**Application by Highways England for the A1 in Northumberland: Morpeth to Ellingham**  
**The Examining Authority's written questions and requests for information (ExQ4)**  
**Issued on 24 May 2021.**

The following table sets out the Examining Authority's (ExA's) fourth round of written questions and requests for information – ExQ4. Questions are set out using an issues-based framework derived from the Initial Assessment of Principal Issues provided as **Annex C** to the Rule 6 letter of 19 November 2020. Questions have been added to the framework of issues set out there as they have arisen from representations and to address the assessment of the application against relevant policies.

Figure 1 - Scheme Plan

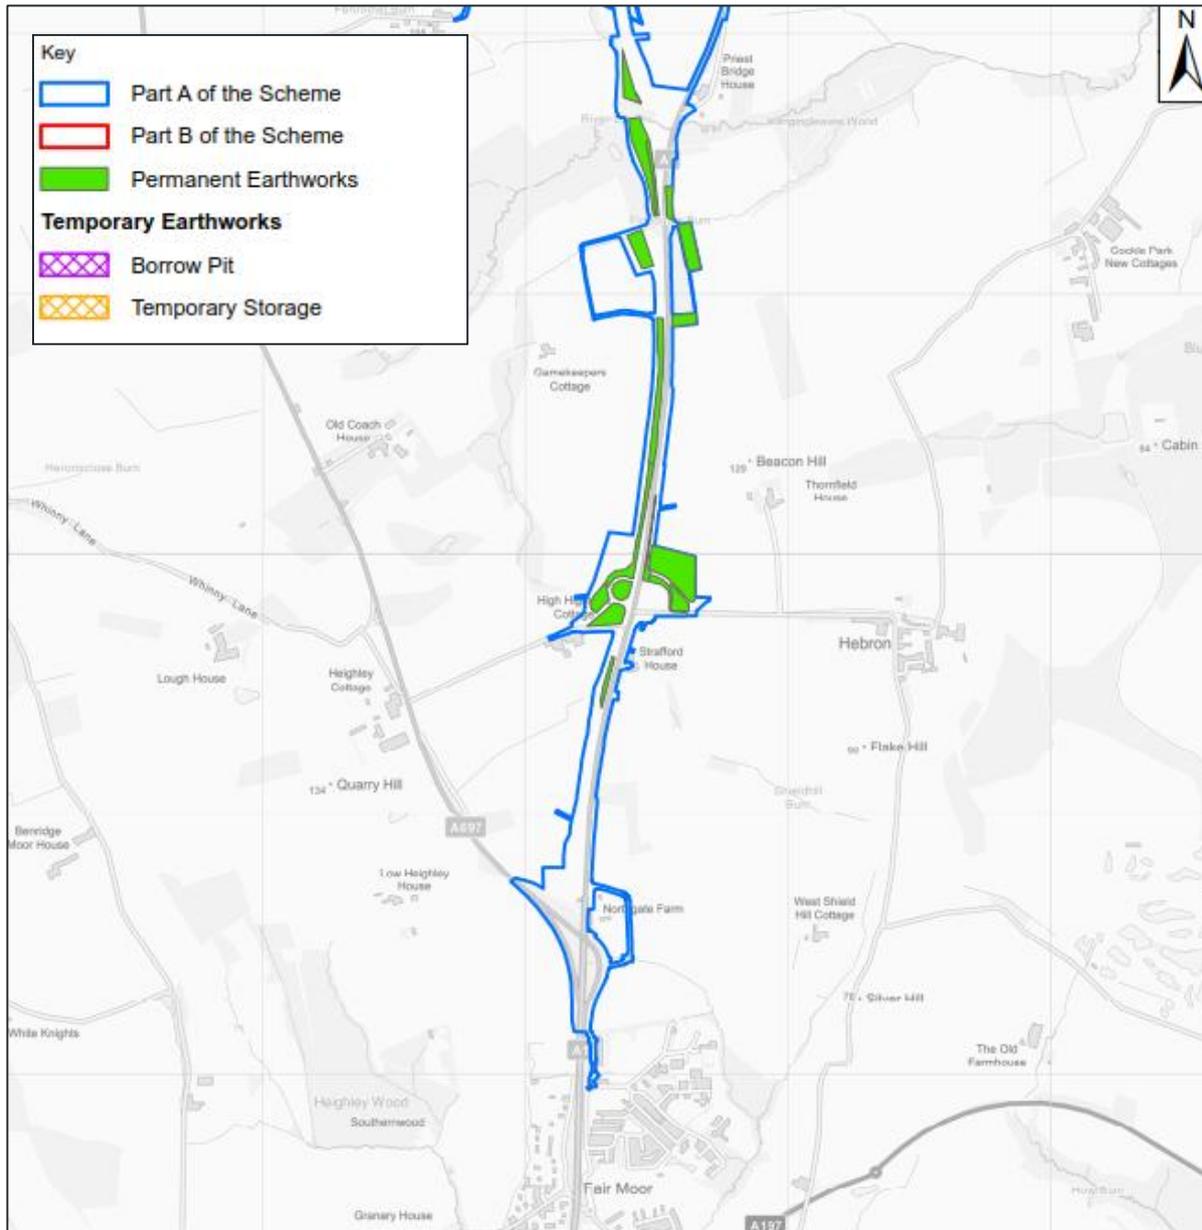
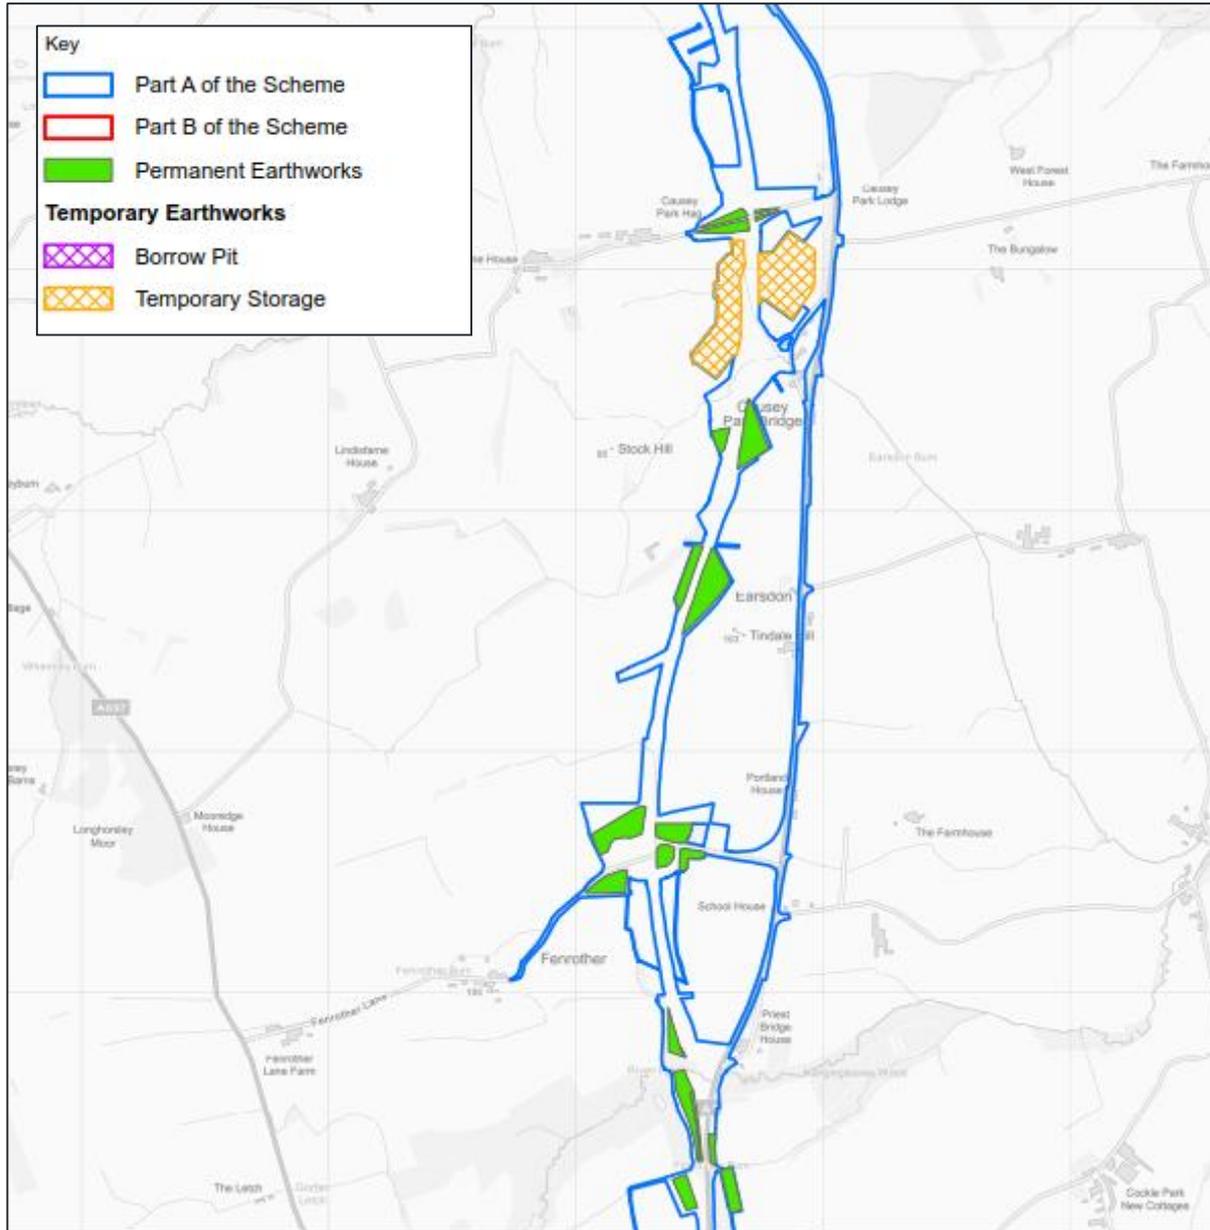
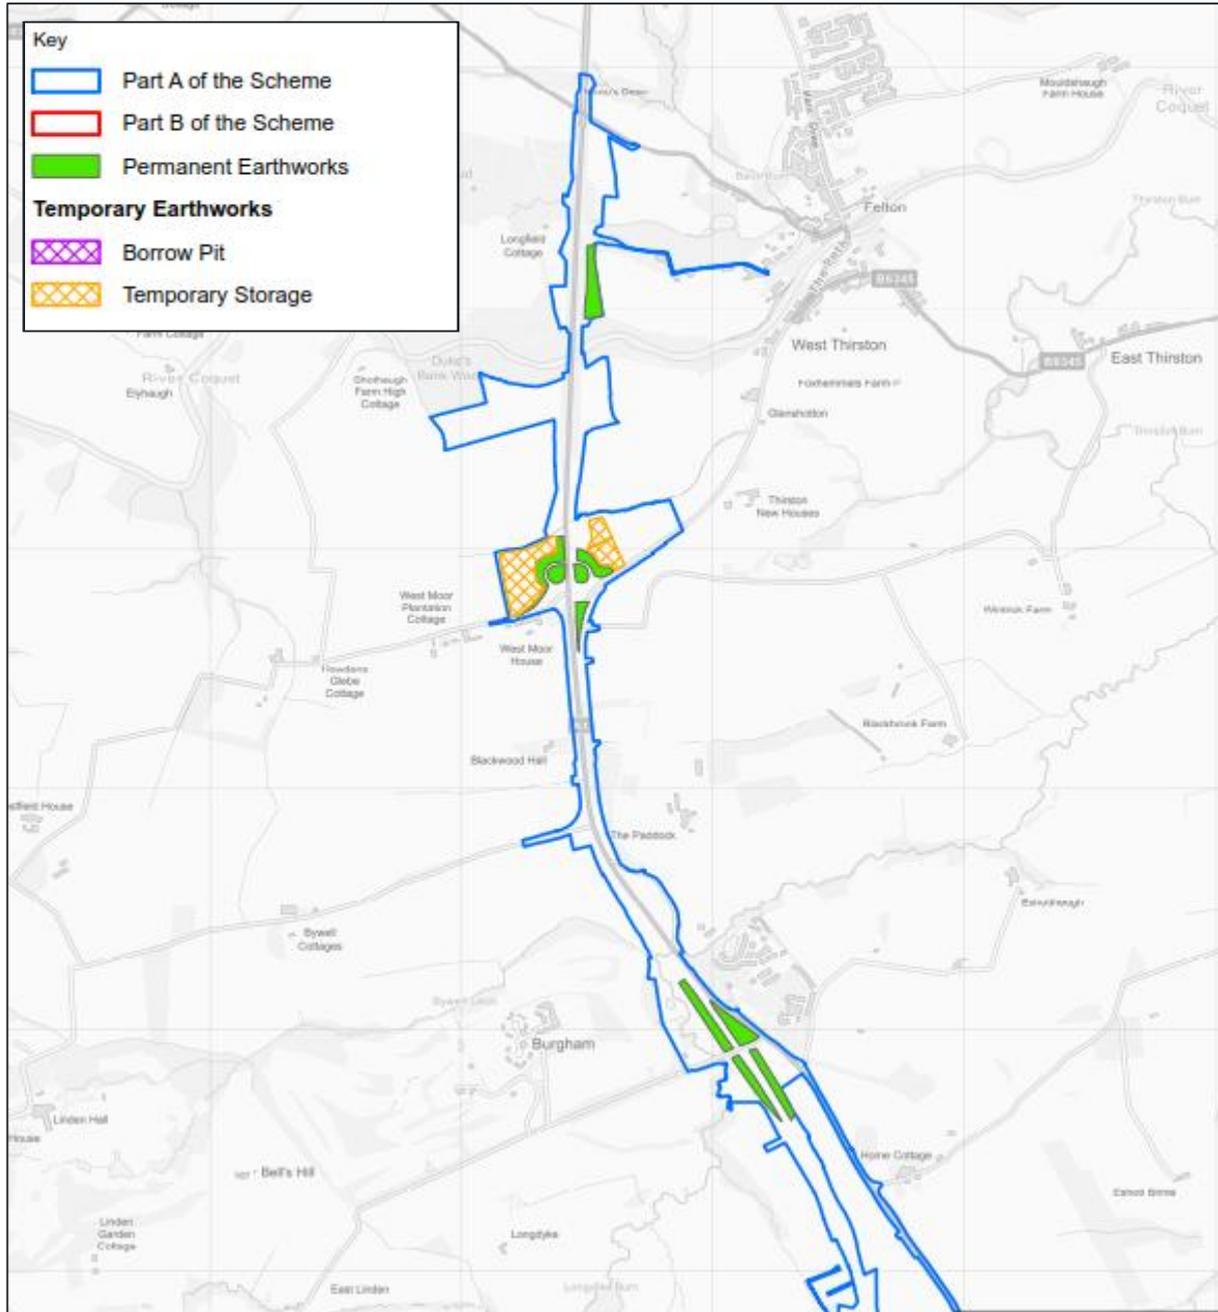
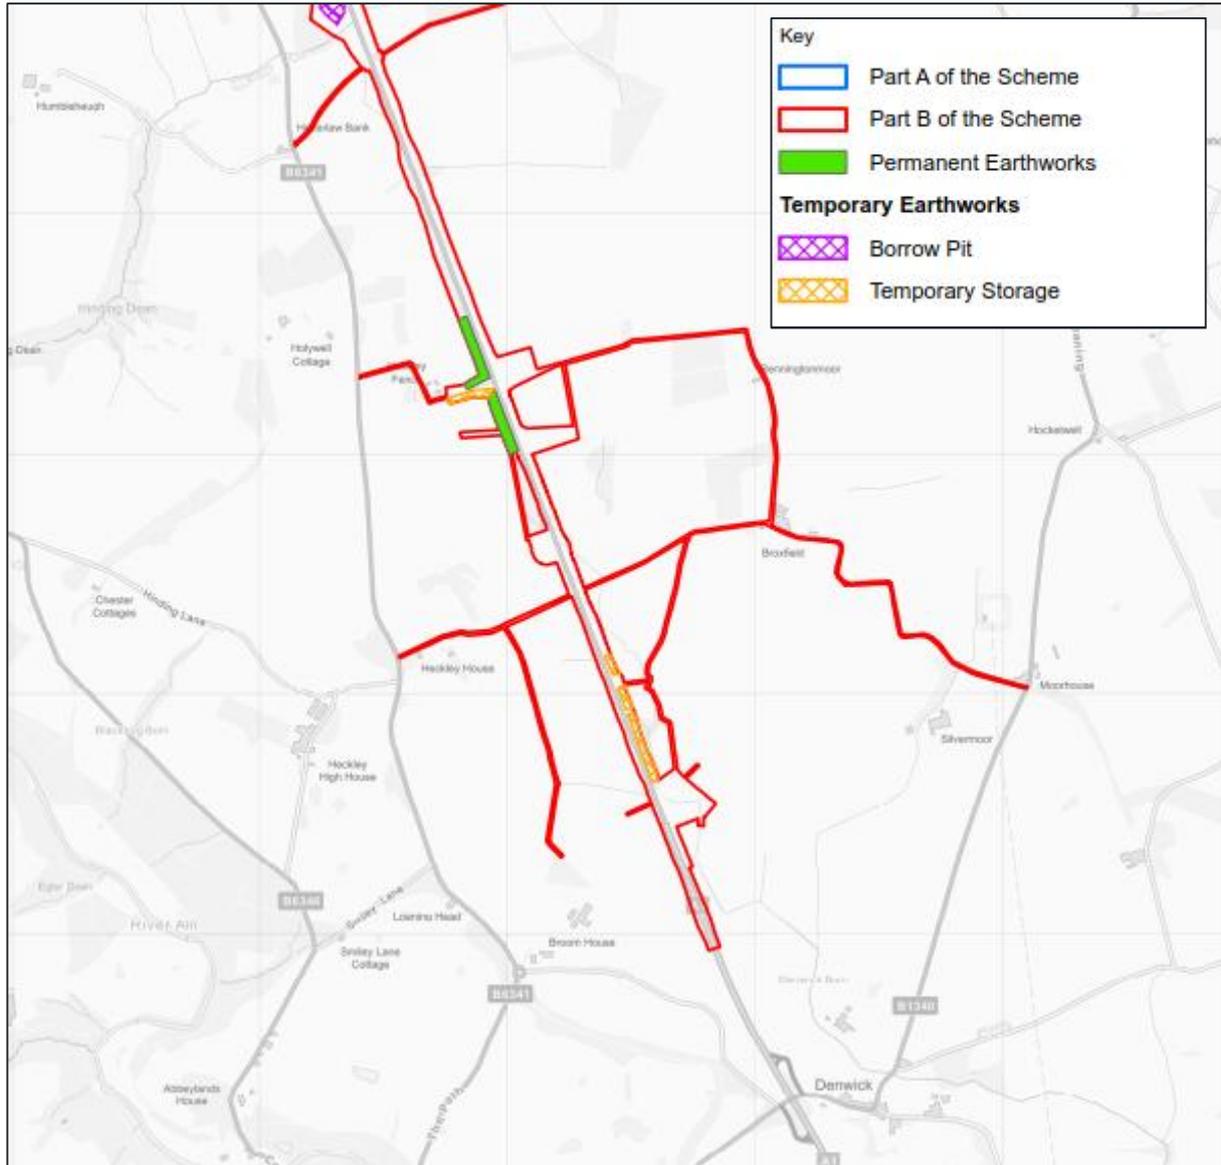
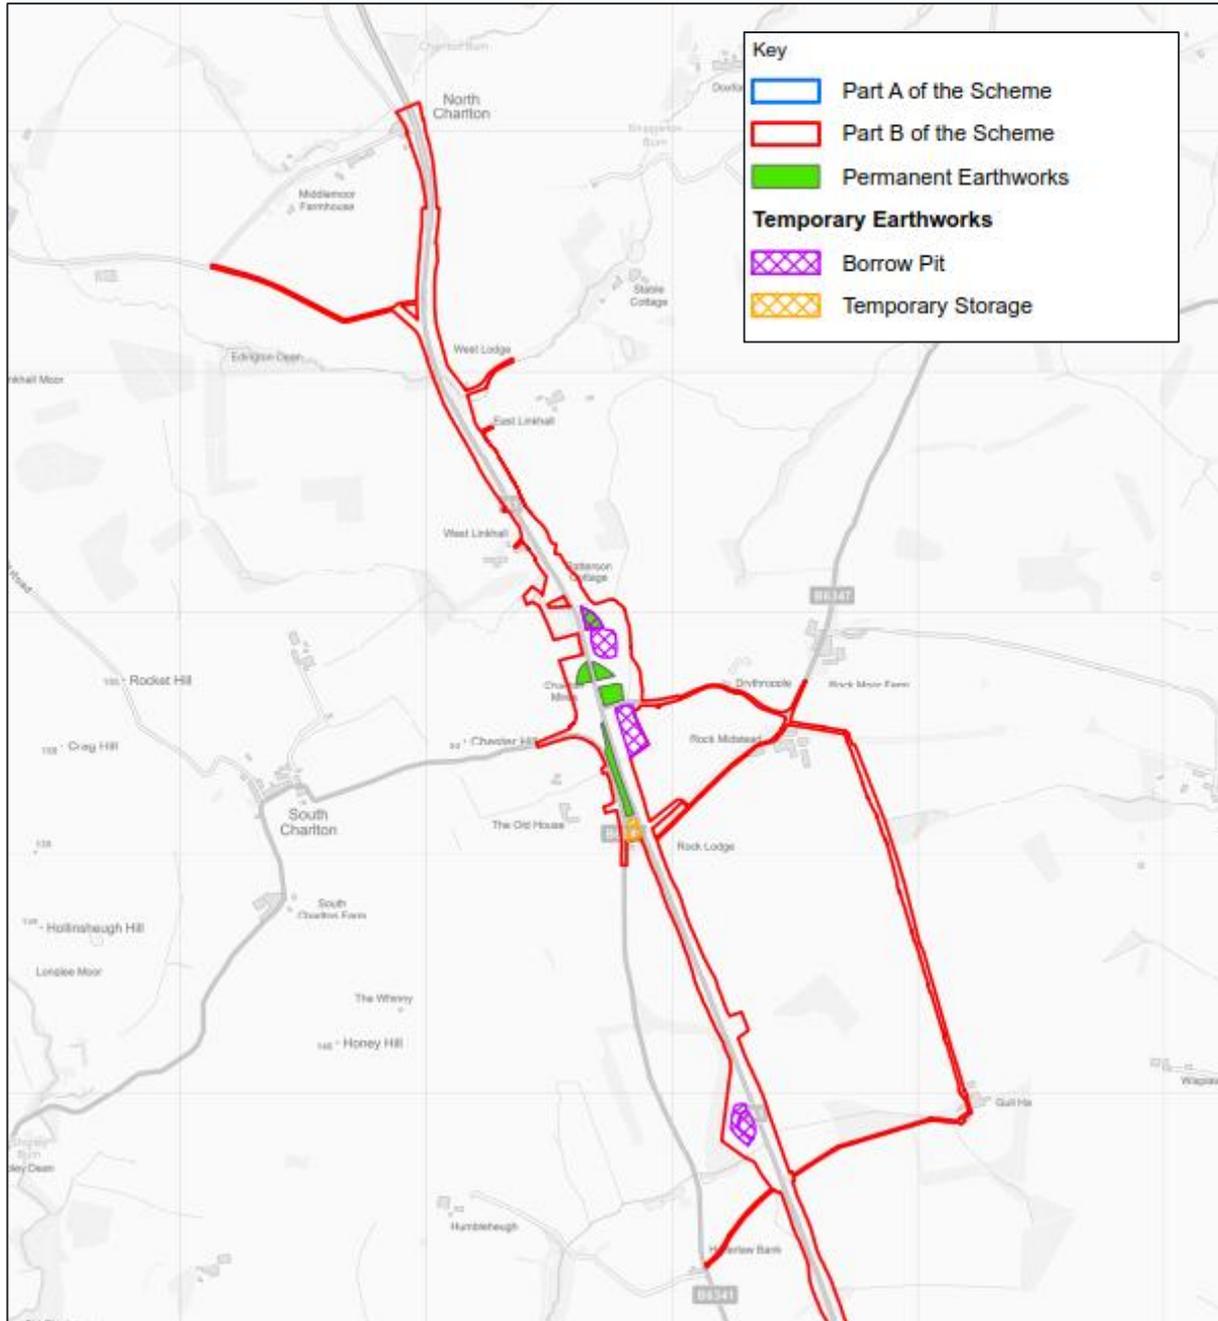
ExQ4	Question to:	Question:
<b>LANDSCAPE AND VISUAL</b>		
LV.4.1	Applicant	<p>[REP4-062] Earthworks Amendments - Non-Technical Summary - Rev 1 states that twenty-two receptors would experience beneficial visual impacts once the Earthworks Amendments are constructed, as a result of the proposed soil bunds, the slackening of slopes and raised levels of the junction 'bowls'. In addition, one residential receptor would experience beneficial visual impacts as a result of the proposed increase in height of a proposed bund, which would provide additional screening of the Scheme.</p> <p>Can the Applicant provide further reasoning and explanation on how such visual impacts were assessed in relation to the twenty-three identified receptors and why such impacts have been assessed as a benefit?</p> <p>Can the Applicant also confirm whether the effects of the above mentioned earthworks have been assessed in relation to landscape?</p>

<b>Part A</b>
LV.4.2	Applicant	<p>[REP4-062] Earthworks Amendments - Non-Technical Summary - Rev 1 states that proposals for Part A of the Scheme would be achieved by a series of measures, including:</p> <ul style="list-style-type: none"> <li>• The increase in height of soil bunds already proposed in the original ES would maximise use of soil bunds for disposal of excess site material.</li> <li>• Maximising of fill within slackened (gentler) slopes for re-use of site material, as proposed in the original ES.</li> <li>• Laying down additional material increasing some localised ground levels.</li> <li>• Raising levels of junction "bowls" (level or rounded rather than dished).</li> </ul> <p>Can the Applicant confirm the proposed maximum height of the proposed soil bunds, slopes and bowls and how the impacts have been assessed in terms of visual effects and effects on the landscape?</p>
		<b>Part B</b>

LV.4.3	Applicant	<p>[REP4-062] Earthworks Amendments - Non-Technical Summary - Rev 1 states that there would be a proposed reduction of imported materials of approximately 132,000 m<sup>3</sup> (of which approximately 88,000 m<sup>3</sup> is from Part A of the Scheme) compared to the original</p>

<b>ExQ4</b>	<b>Question to:</b>	<b>Question:</b>
		<p>ES, which is anticipated to lead to approximately 110,000 m<sup>3</sup> to be used onsite rather than being disposed offsite. These proposals for Part B of the Scheme would be achieved by the following:</p> <ul style="list-style-type: none"> <li>• Creation of new soil bunds to maximise re-use of excess site material.</li> <li>• Maximising of slopes for re-use of excess site material.</li> <li>• Laying down additional material increasing some localised ground levels.</li> <li>• Raising levels of junction "bowls" (level or rounded rather than dished).</li> <li>• Creating new, temporary soil storage areas.</li> <li>• Utilising borrow pits to exchange and win additional material suitable for construction.</li> </ul> <p>Can the Applicant confirm the proposed maximum height of the proposed soil bunds, slopes and bowls and how the impacts have been assessed in terms of visual effects and effects on the landscape?</p>

Figure 1 - Stabilisation Works Location Plan

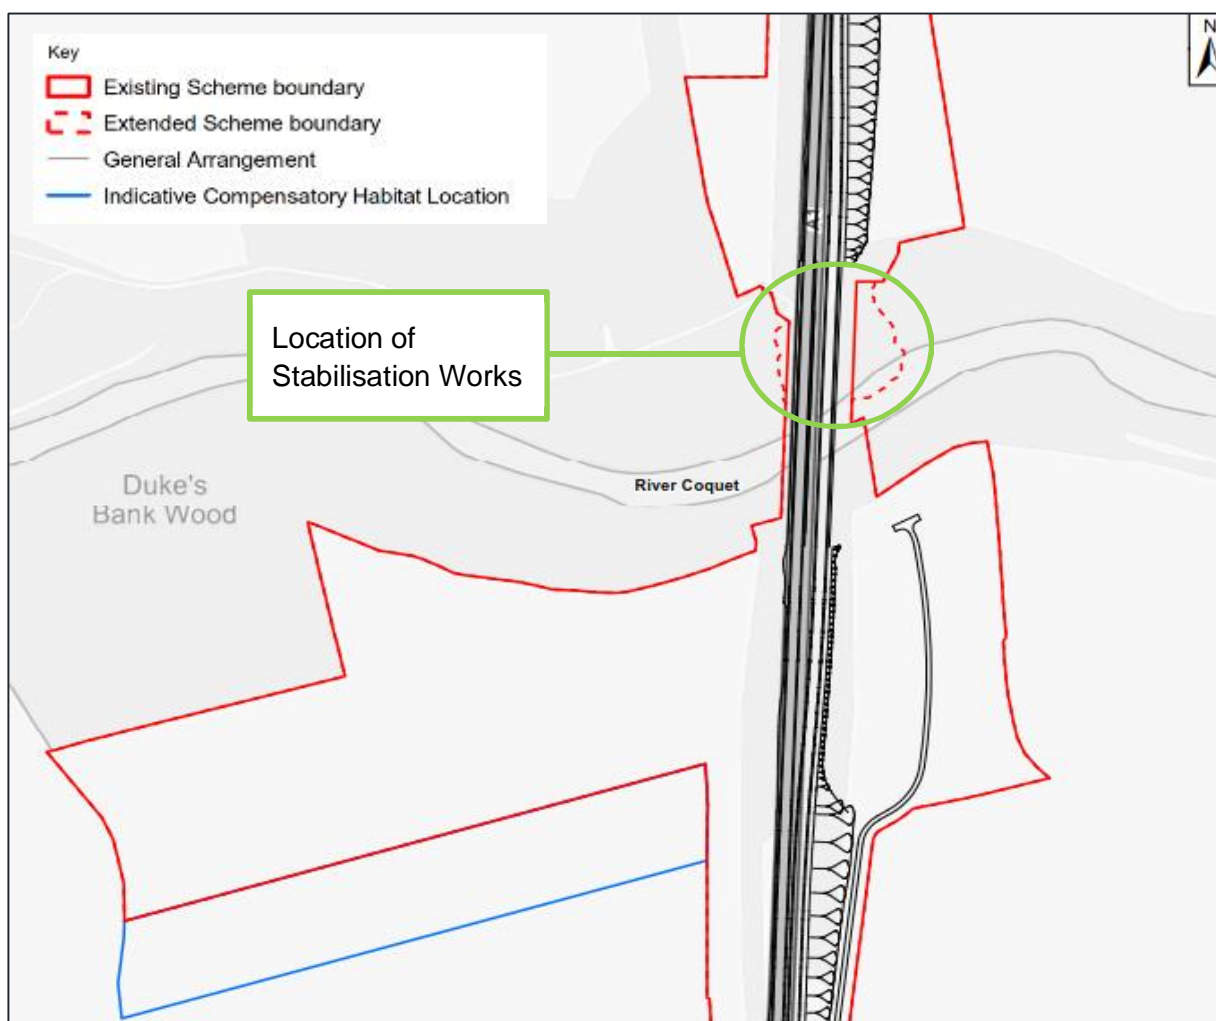
BIO.4.2	Applicant	<p>In its Relevant Representation (RR) submitted at Deadline 7a the Woodland Trust requested that the Applicant explores all potential options that would ensure the safety of the existing and new bridges while avoiding loss of ancient woodland.</p> <p>In responding to the RR submitted by the Woodland Trust, the Applicant is asked to demonstrate what other options were considered to avoid the loss of additional ancient woodland.</p>
BIO.4.3	Applicant	In its RR submitted at Deadline 7a NE reiterated its comments on the proposed changes to the application made at Deadline 5a [REP5a-004].

<b>COMPULSORY ACQUISITION/TEMPORARY POSSESSION</b>		
		The ExA does not wish to ask any further questions on this topic at this point in the Examination.
<b>COMBINED AND CUMULATIVE EFFECTS</b>		
CC.4.1	Applicant	NE [REP5a-004] states that, when the cumulative impact of the works on both northern and southern banks of the River Coquet are assessed over the lifetime of the scheme, the permanent loss of the natural bed and bank features, the decoupling of the channel from the sediment supplied by the gorge slopes and the cessation of the natural evolution of the channel over even a limited area of the SSSI, should be viewed as a significant impact on this nationally important river system.

<b>ExQ4</b>	<b>Question to:</b>	<b>Question:</b>
		The Applicant is asked to comment on how it has assessed the combined and cumulative impacts of the proposed change on the River Coquet and if it views such impacts as significant.
<b>DRAFT DEVELOPMENT CONSENT ORDER</b>		
		The ExA does not wish to ask any further questions on this topic at this point in the Examination.
<b>GEOLOGY AND SOILS</b>		
GS.4.1	Applicant	NE [REP5a-004] has highlighted concerns regarding the effects of the proposed changes to the application on the geomorphology of the River Coquet. Furthermore, NE agrees with the EA [REP6-053] [REP7-021] in relation to the Change Request Addenda in relation to the geomorphological impacts of the proposal. The NE and EA believe that the proposed bank stabilisation works, and the scour protection works will constitute a break in the connectivity between the terrestrial and riverine habitat, with long-term implications for local sediment supply in this area. This, in the view of NE and the EA does not constitute a minor adverse impact.  Can the Applicant confirm why it considers that the permanent loss of natural riverbank would constitute a minor adverse impact?
